**RESPONSES TO EXAMINING AUTHORITY'S
QUESTIONS 22/03/19**

**ON BEHALF OF THE
HISTORIC BUILDINGS AND MONUMENTS COMMISSION FOR ENGLAND
(HISTORIC ENGLAND)
("HBMCE")**

**Application by
Highways England for an Order granting Development Consent for the A303
Sparkford to Ilchester Dualling**

PINS Reference No: SPIL-SP0005 & 2001-4933

ENGINEERING SECTIONS

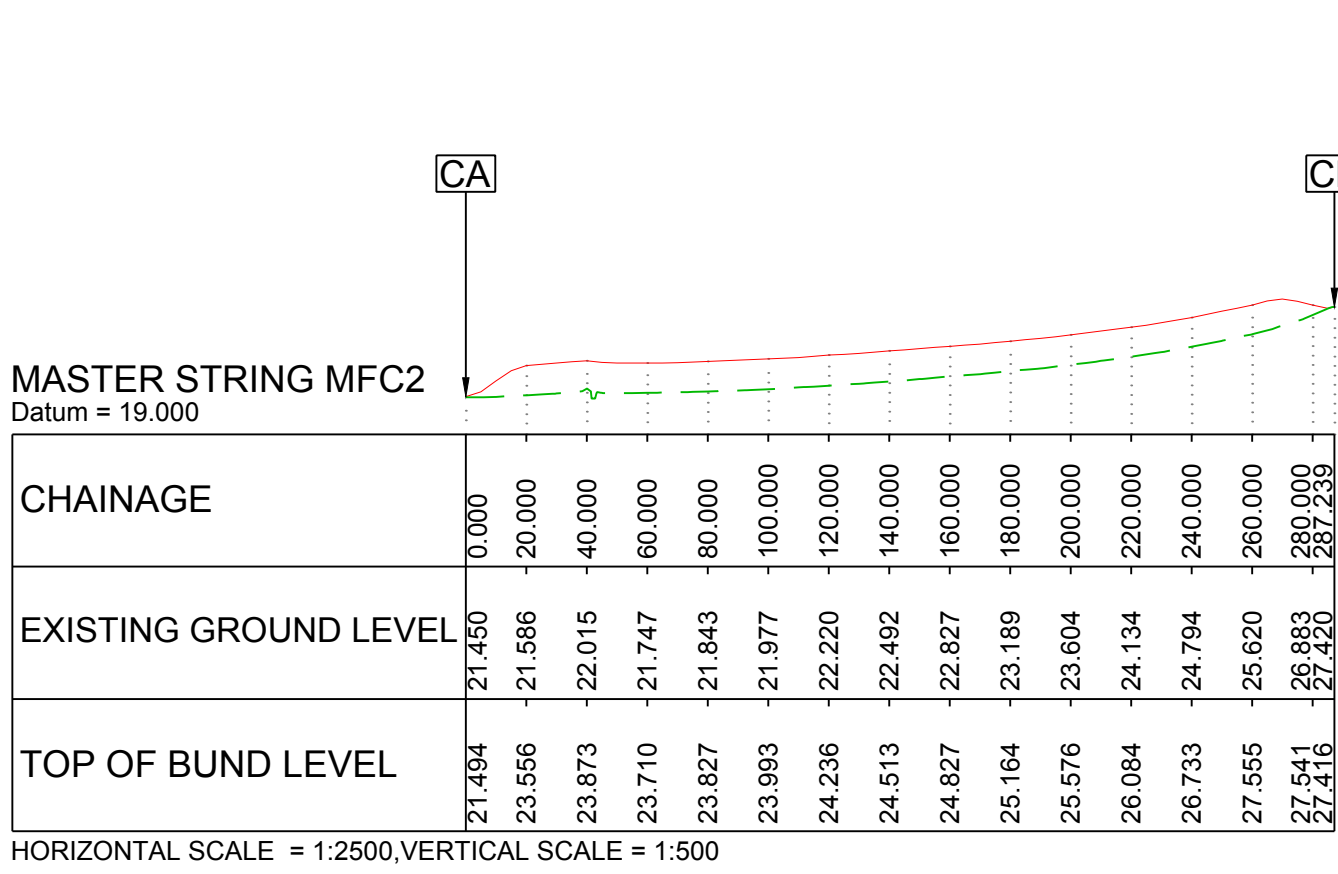
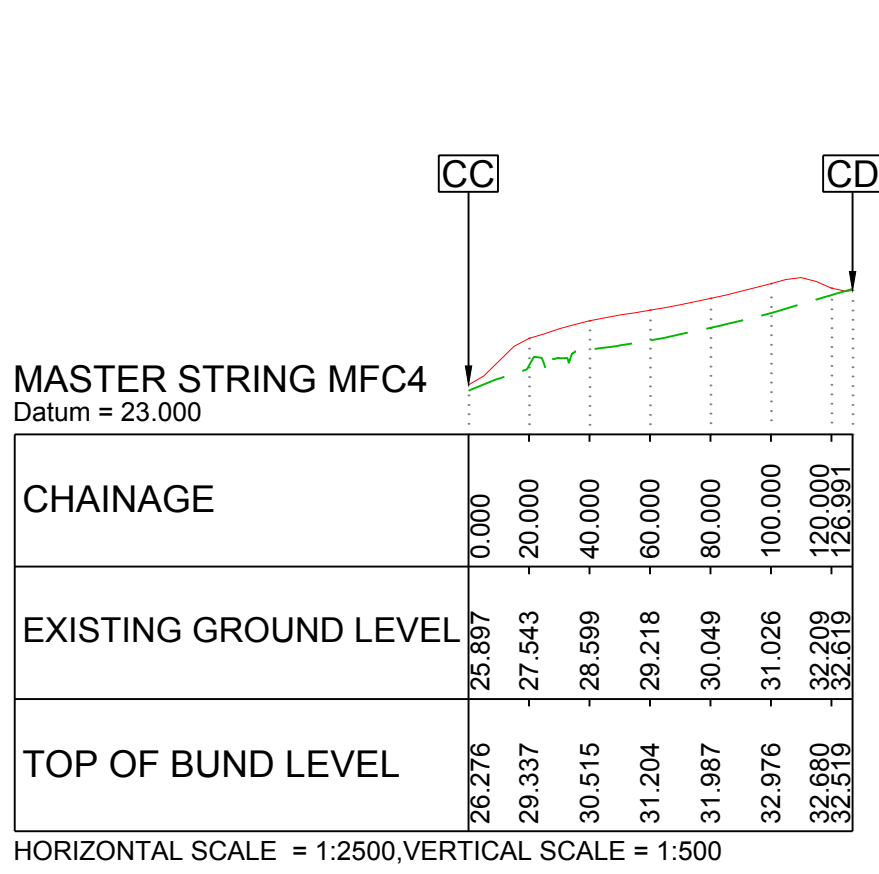
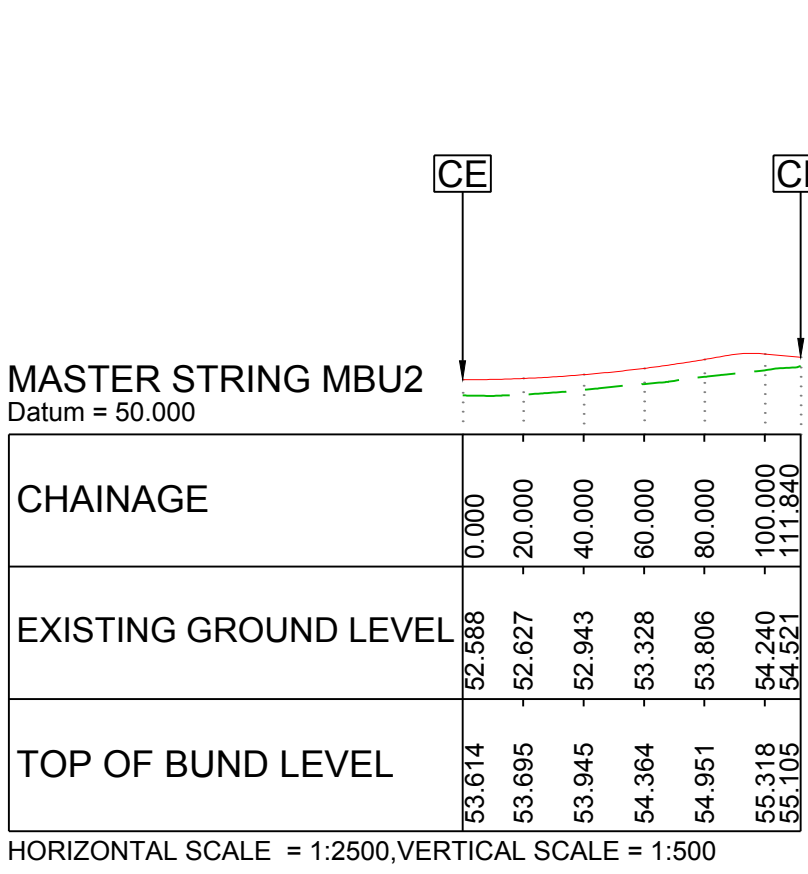
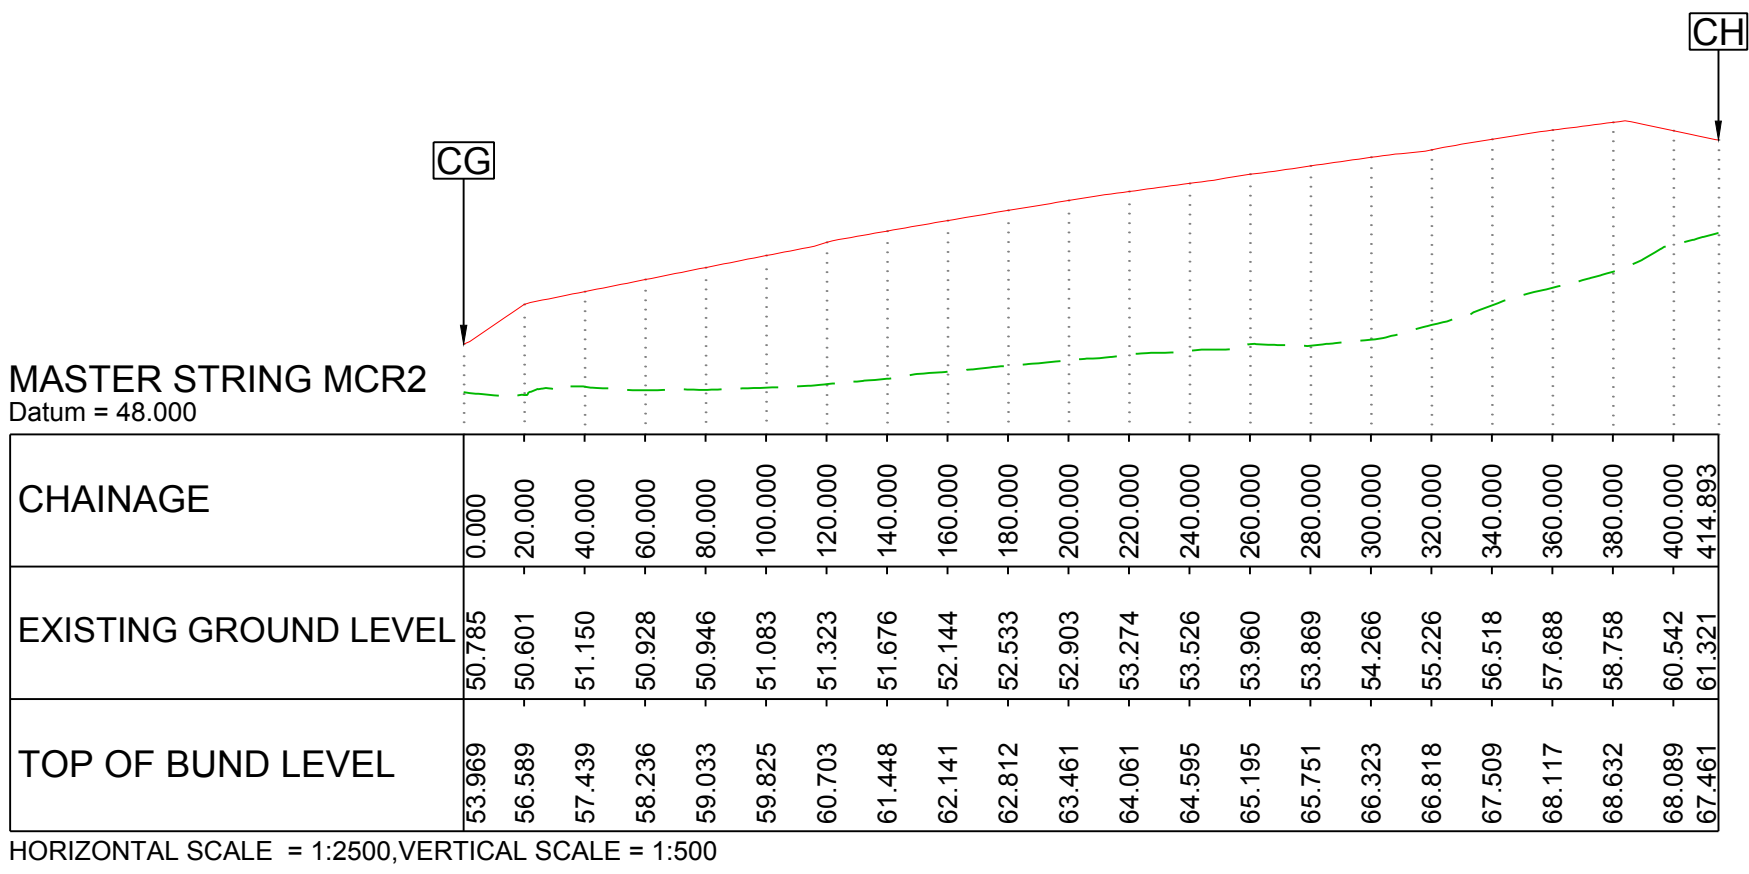
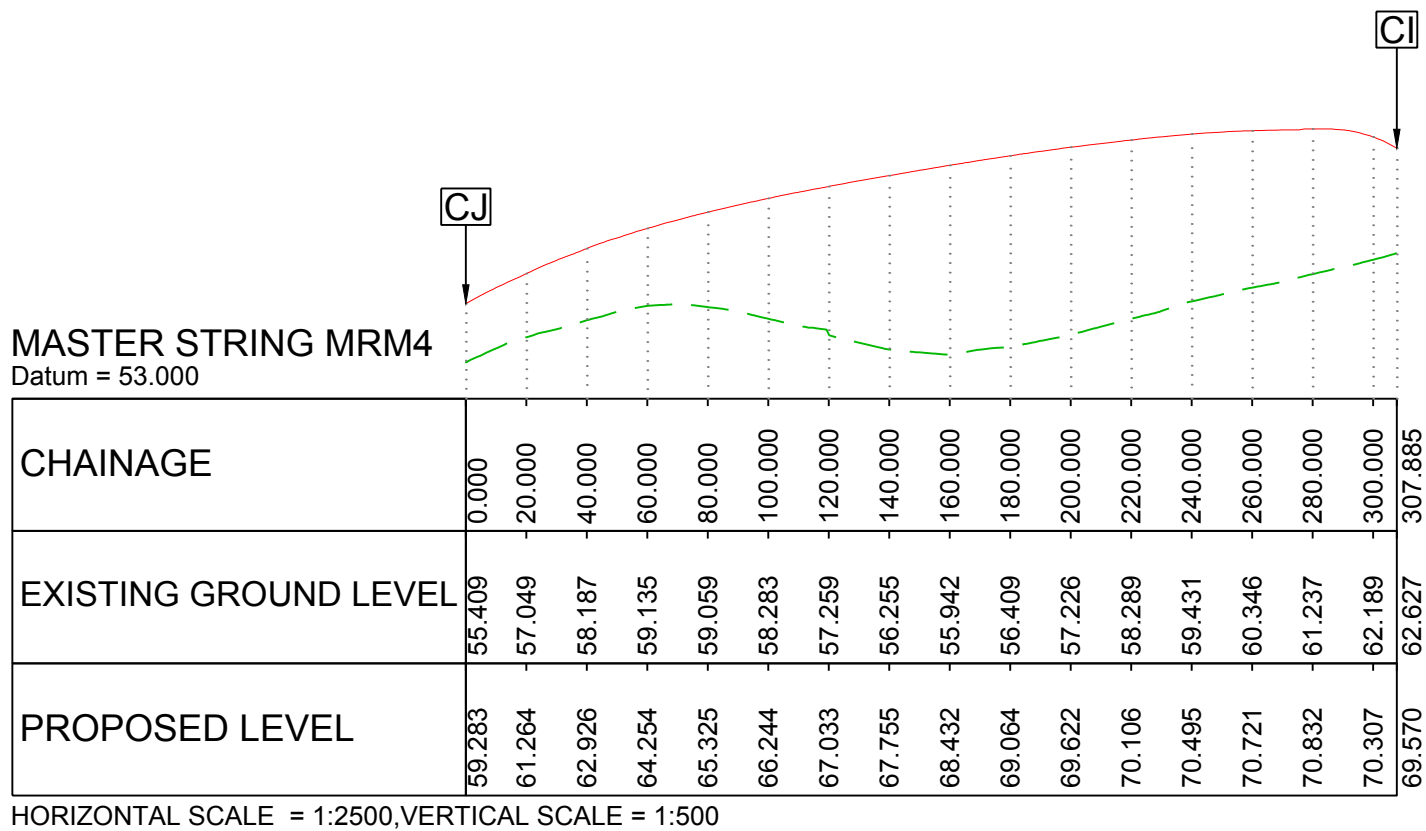
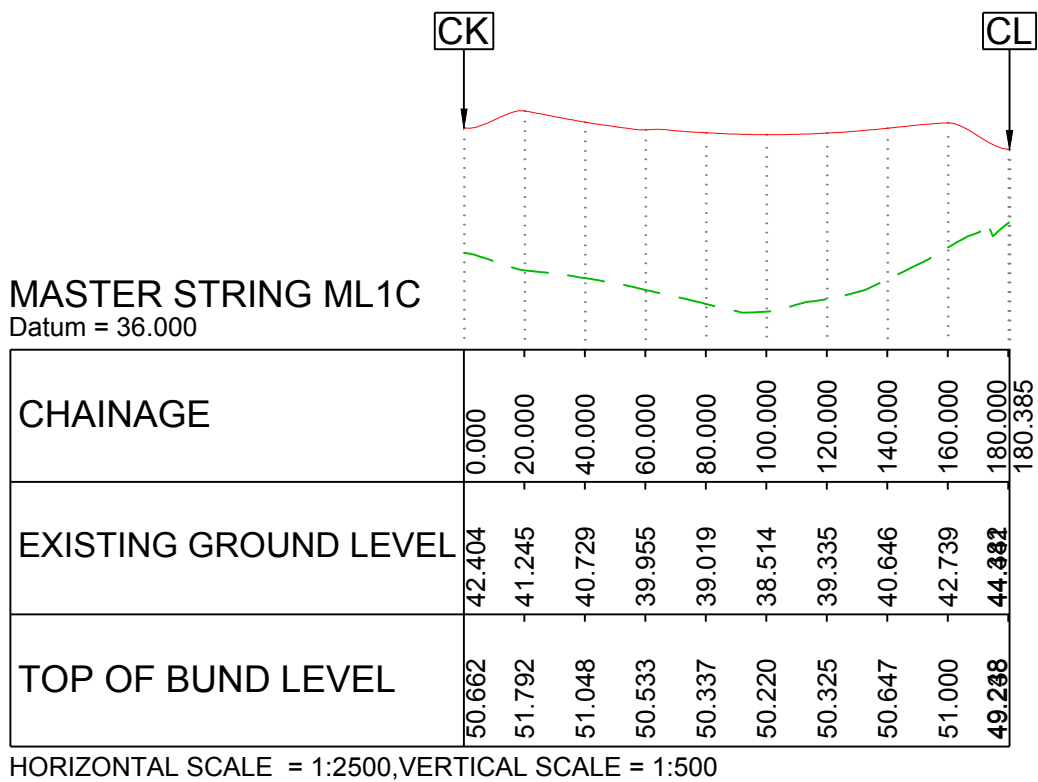
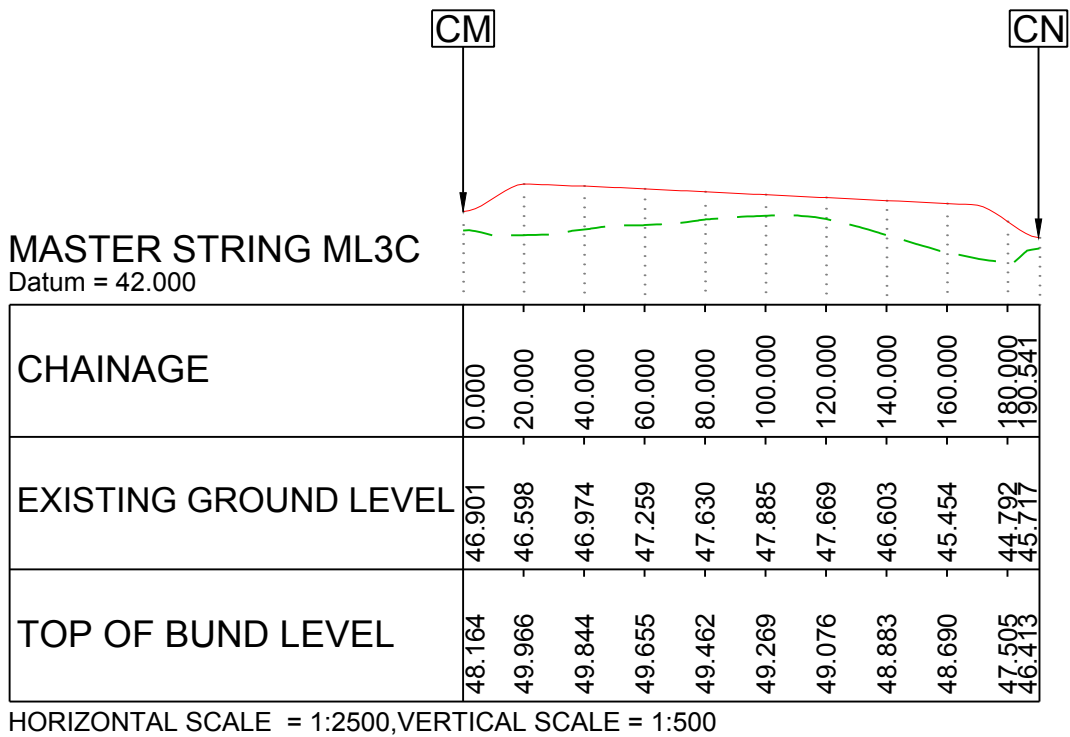
HMBCE has reviewed the landscape sections through Hazlegrove Junction submitted for Deadline 4. We consider them to be very helpful in illustrating how the bunds and proposed planting aim to screen the road. We would however maintain that, as set out in our Written Representation, para 7.5.3. (e) *'We do not consider that the design of the false cuttings and screen planting would remove all moving traffic from historic views from the park. We agree that in the longer term, when the planting is in leaf and reaching maturity, moving traffic may be removed, but we consider that large vehicles such as coaches and HGVs may be visible during winter months.'*
